# CITY OF PORTLAND BUILDING PERMIT

Located At 68 IRVING

Job ID: 2011-02-446-DUP

has permission to Fire Blocking, handrails, fire doors, new electrical, plumbing after fire provided that the person or persons, firm or corporation accepting this permit shall comply with all of the provisions of the Statues of Maine and of the Ordinances of the City of Portland regulating the construction, maintenance and use of the buildings and structures, and of the application on file in the department.

# 1st Floor

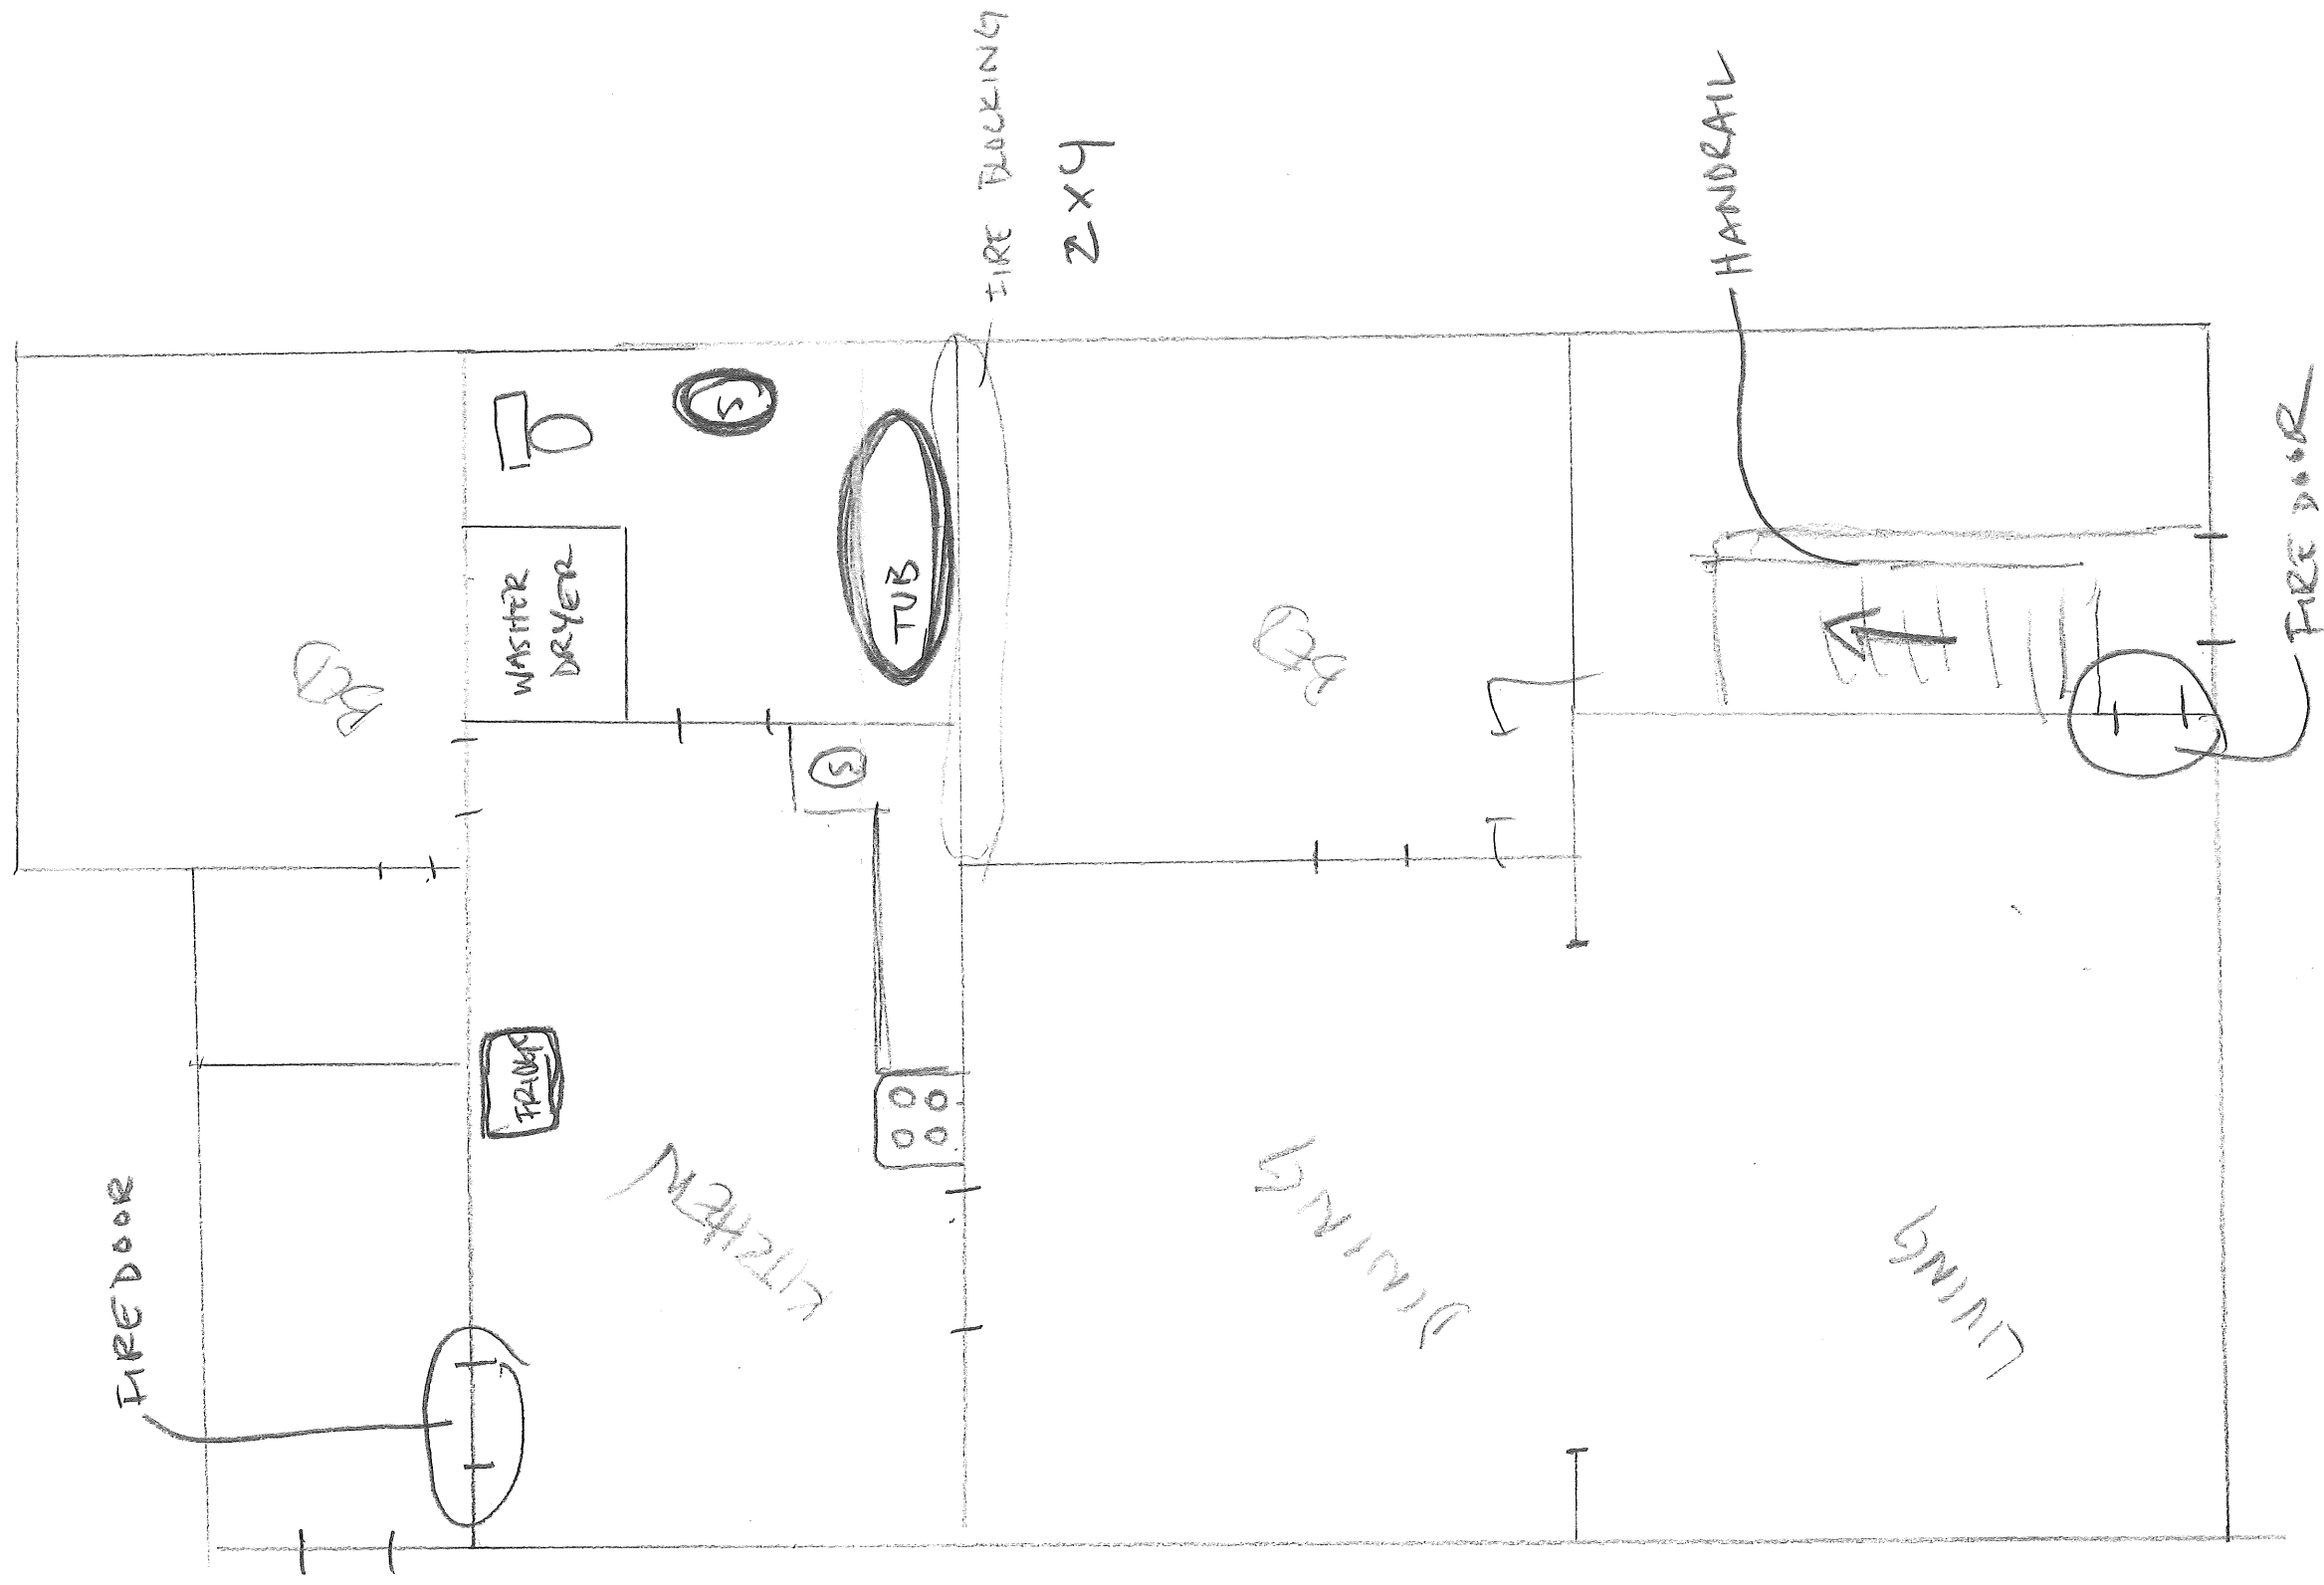
Need to handle +  
Intercom smoke within  
units. Needs to  
Remove all kitchen  
equipment in office.  
Clean up elec in  
Basement. Remove mold by  
+ Porch  
NLP

5-20-11  
all issues corrected  
elec issue code  
NLP

# 3RD FLOOR

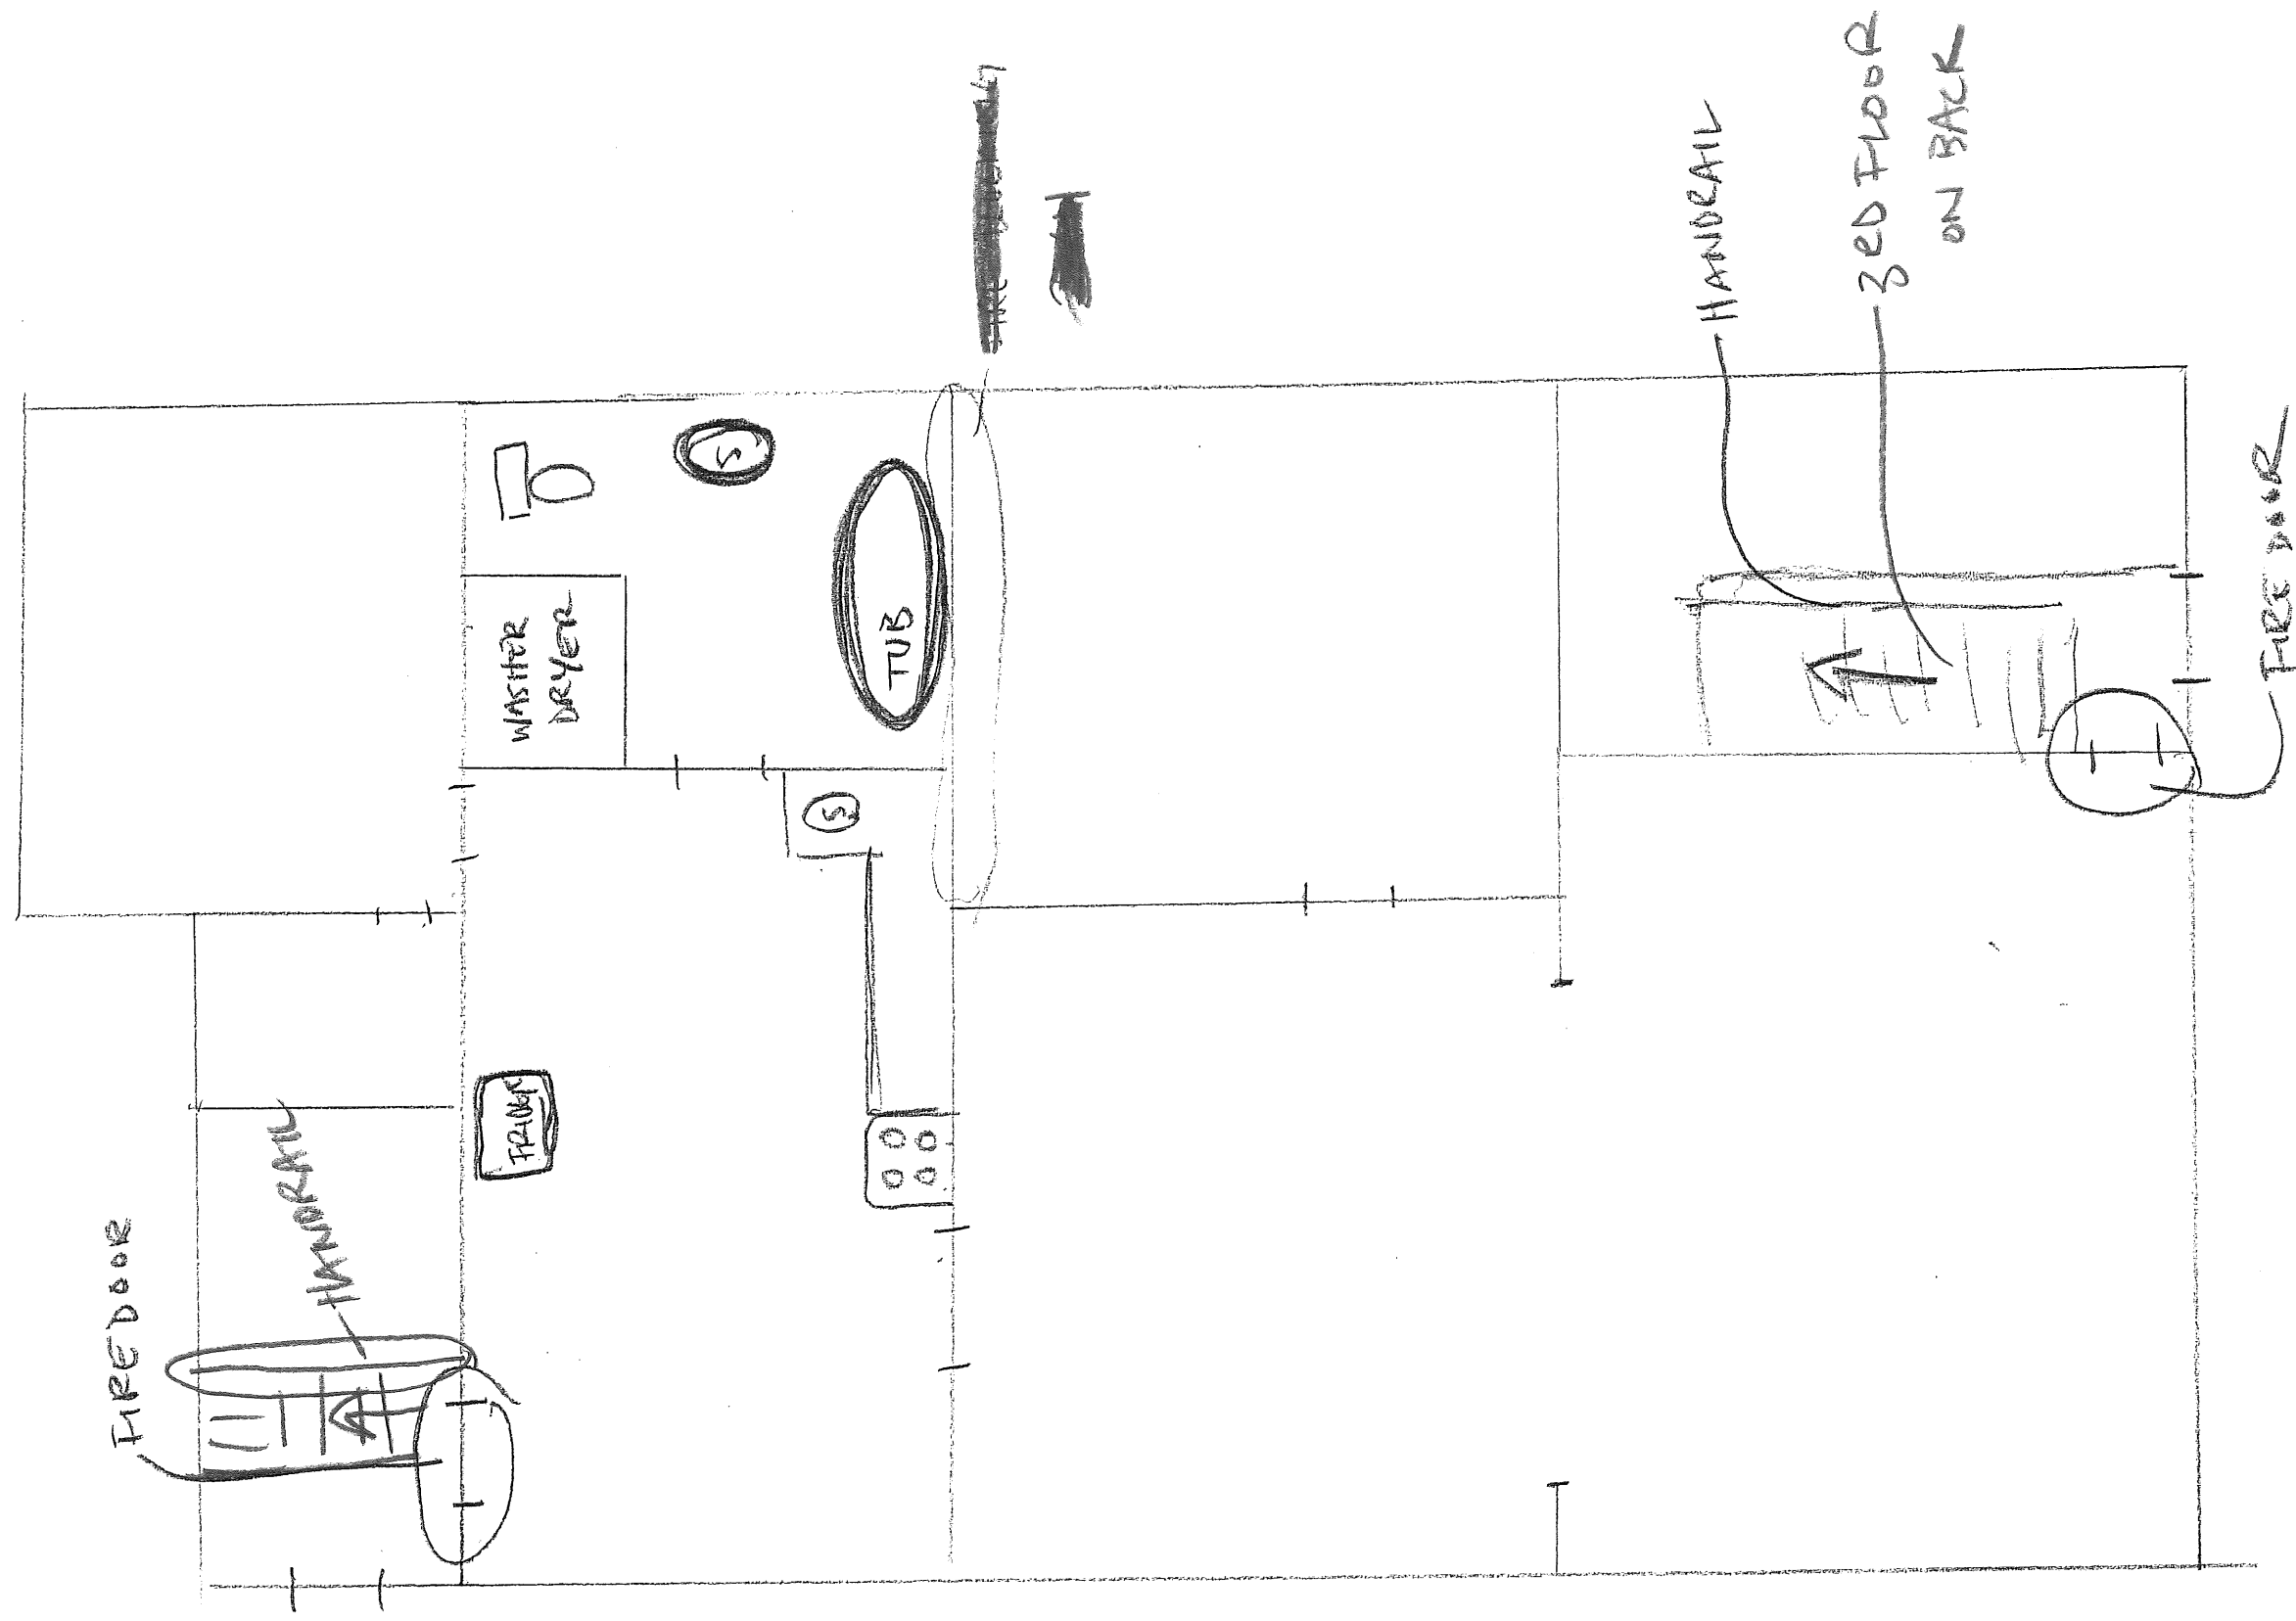
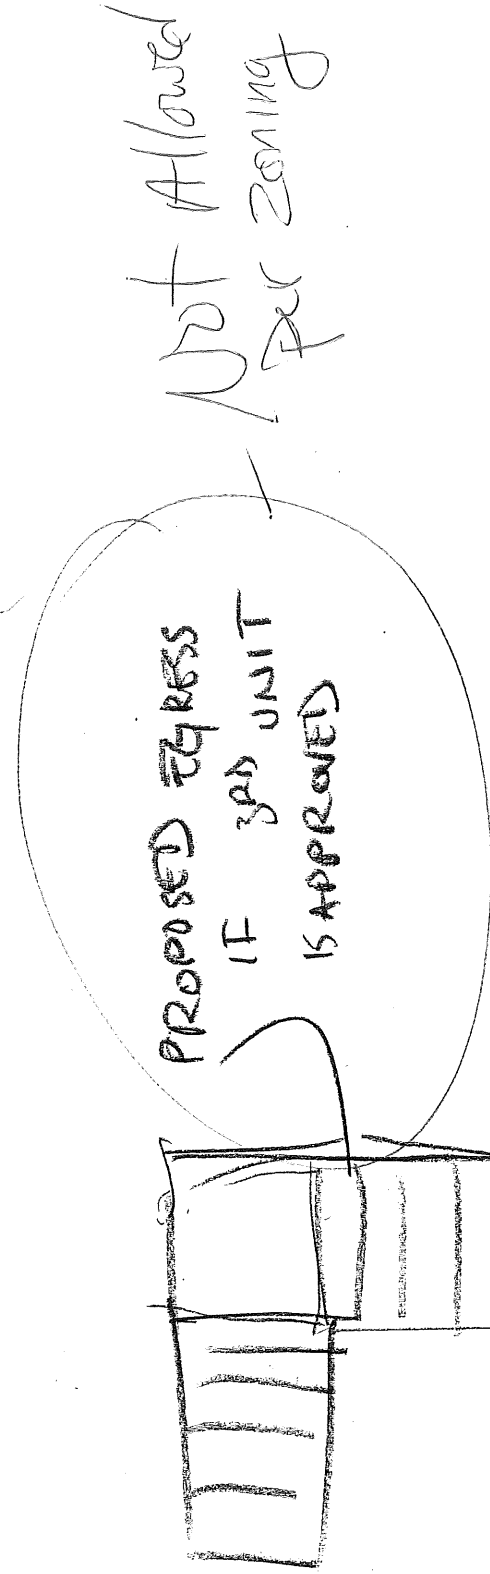
1. This permit is being approved on the basis of plans submitted. Any deviations shall require a separate approval before starting that work.
2. This property shall remain a two family dwelling. Any change of use shall require a separate permit application for review and approval. There is an illegal dwelling unit in the attic. The unit must be removed or the owner needs to apply to legalize it.

Not Allowed  
Per zoning

No kitchen  
Allowed
